Planning Application Ref: AW/252/21/T

Location: 23 West Avenue, Aldwick, PO21 3QP

Description of works: 1no. oak (T1) - Reduce tree by 2 metres all round leaving 8m spread all around

T1 Oak Tree

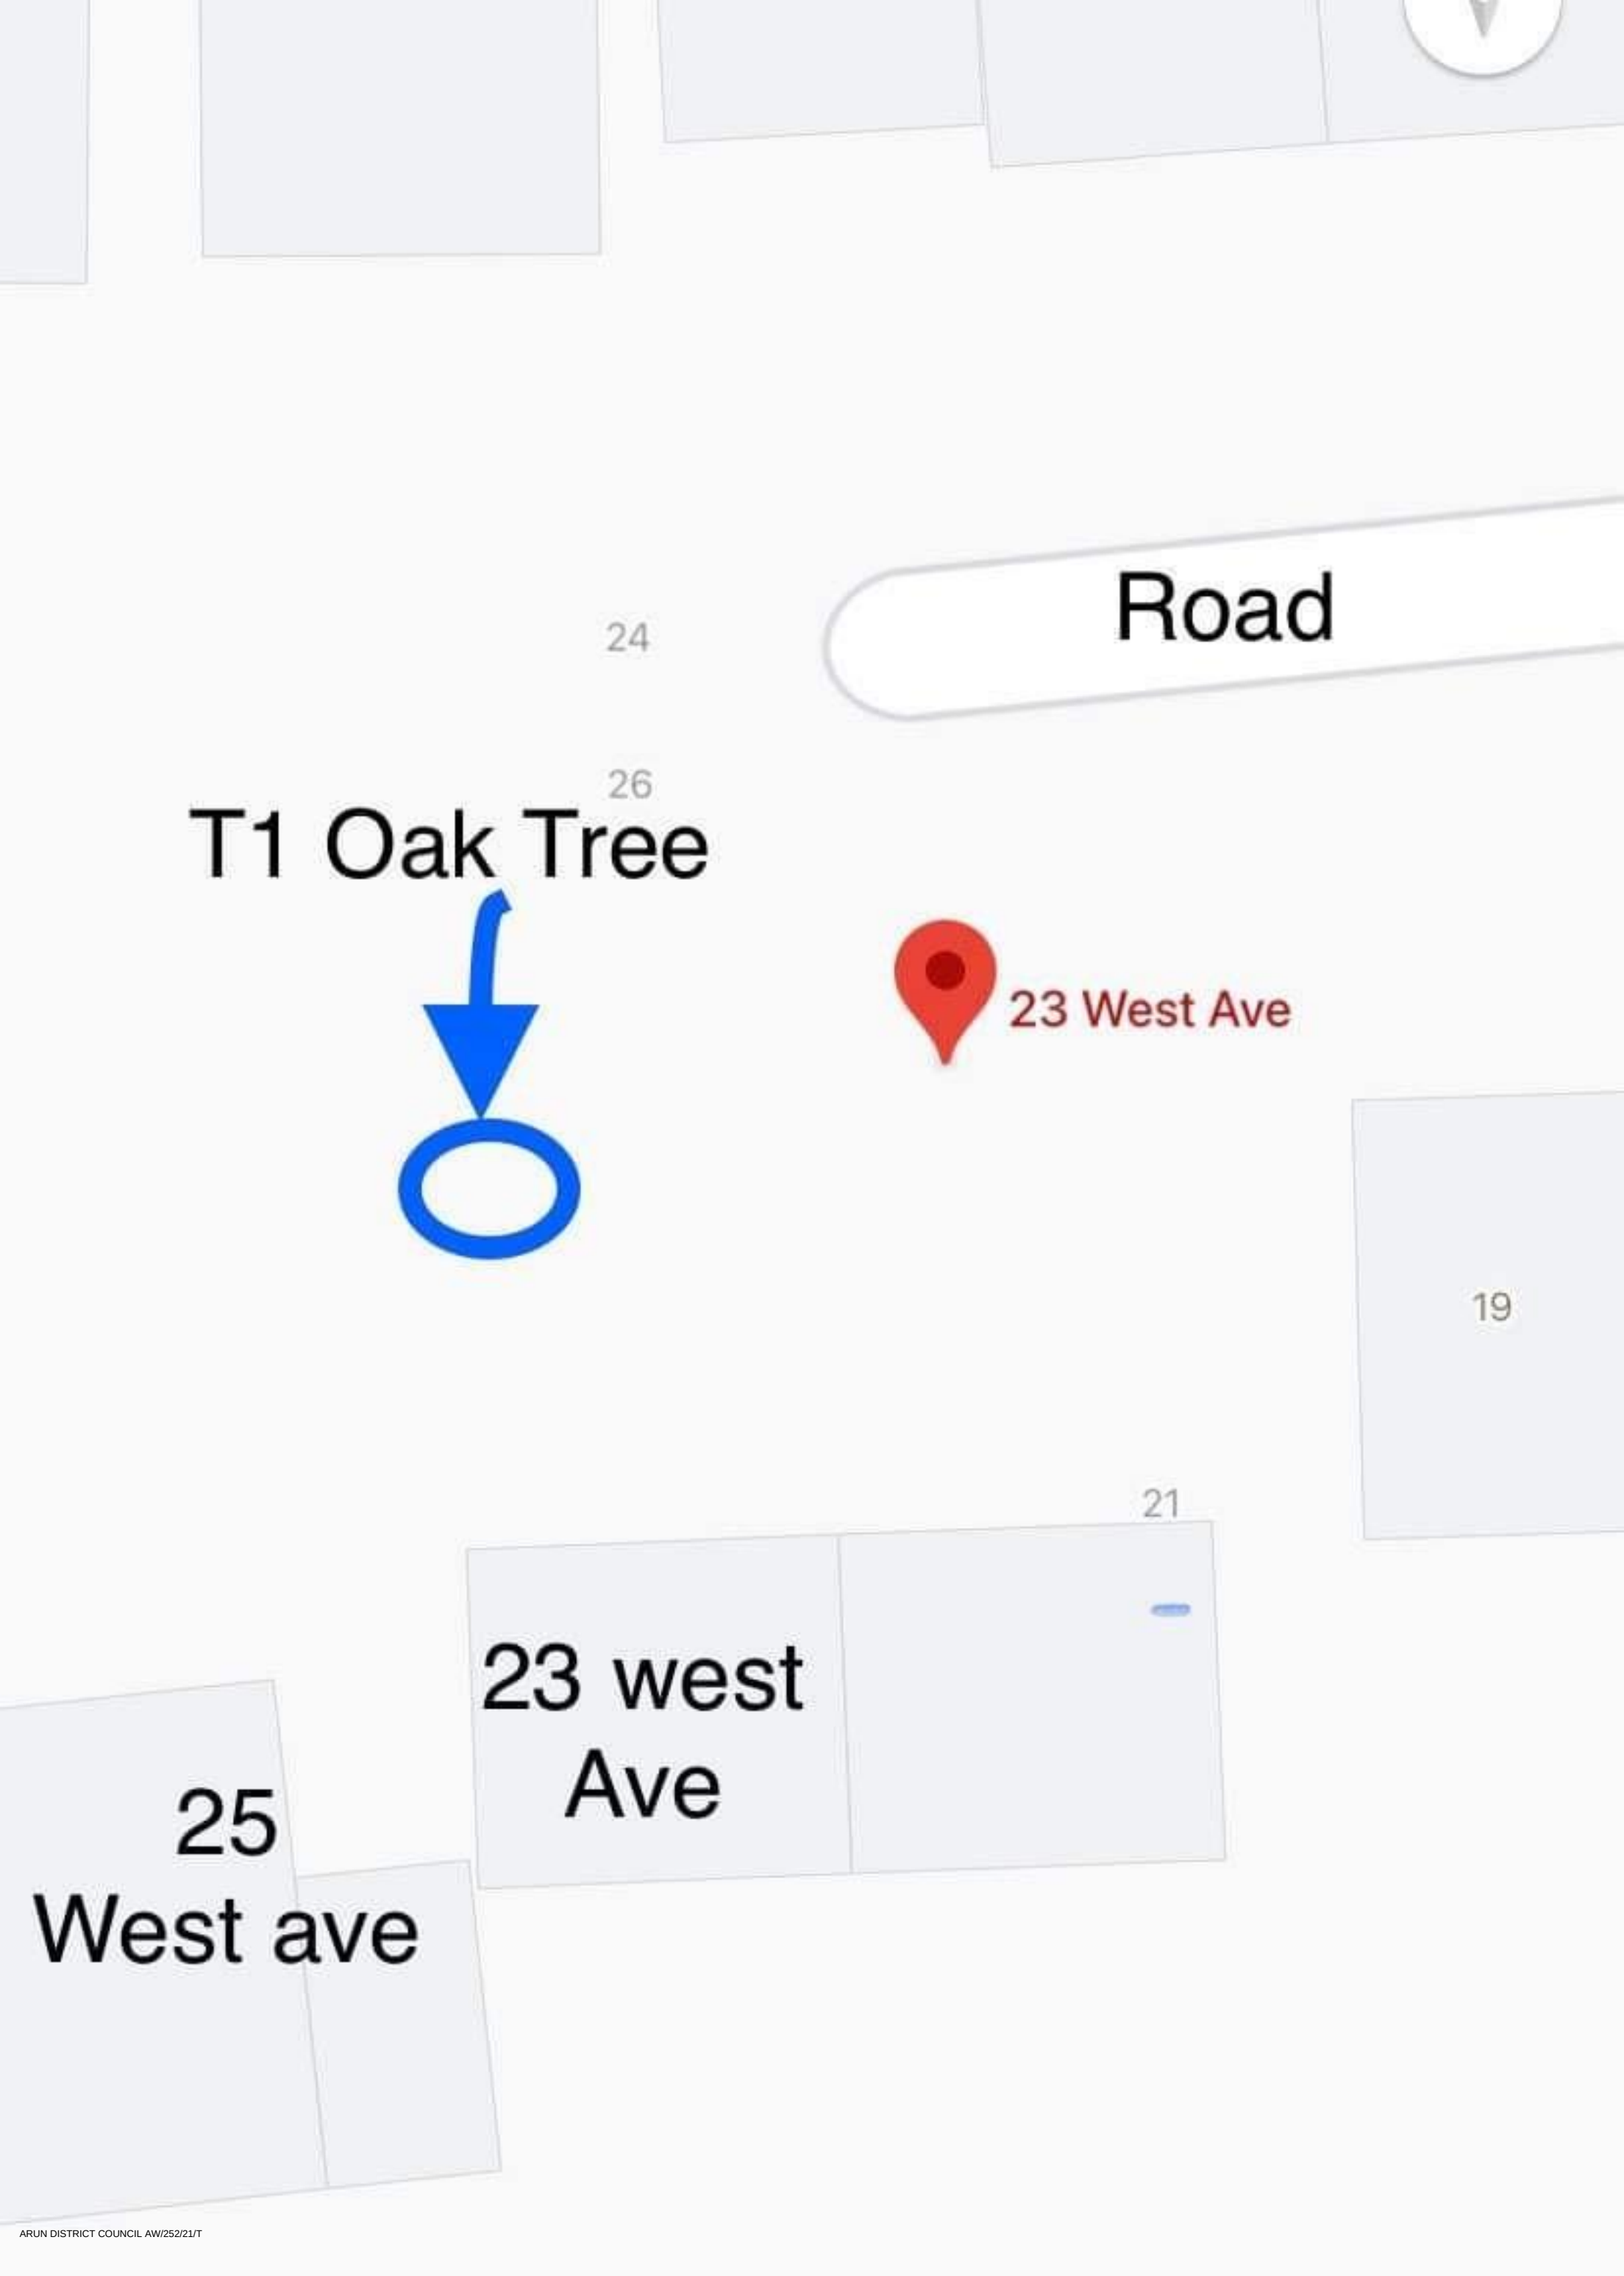
- This is an established tree of apparent good health. It has been the subject of several crown modifications resulting in a dense, compact form. It is visible from numerous properties and to users of the public highway (footway and carriageway).
- There has been 1-2metres of growth since the last crown reduction. I cannot say the proposal to reduce its overall height and spread is consistent with previous work approved by the Local Planning Authority as I have not been able to retrieve a past permission for that operation.

- Repeat operations such as now being asked for by the applicant will be necessary throughout the remaining lifespan of this tree, to achieve a reasonable degree of structural integrity appropriate for its location.
- If the work is undertaken to a good standard and at the right time; then it is unlikely to have an adverse effect on the tree's long-term vitality and visual amenity.

- I recommend **CONSENT** for this application, subject to the following condition:

Part a) Where whole branches are to be removed and final cuts made close to the trunk or branch union they are to be made as shown in Figure 2 of BS3998:2010

Part b) Where branches are to be shortened back the final cuts are to be made at the correct angle shown in BS3998:2010 and adjacent to a live bud or lateral.

Part c) Where crown reduction pruning has occurred previously, then the removal/reduction of branches which have developed since the last operation must be done sympathetically and with respect to established 'knuckles' so as not to extend beyond the point of origin.

- The long-term vitality of this tree is best respected when significant pruning work such as proposed, is undertaken during the late spring to summer period (May to August). The work proposed should only be undertaken during this period.
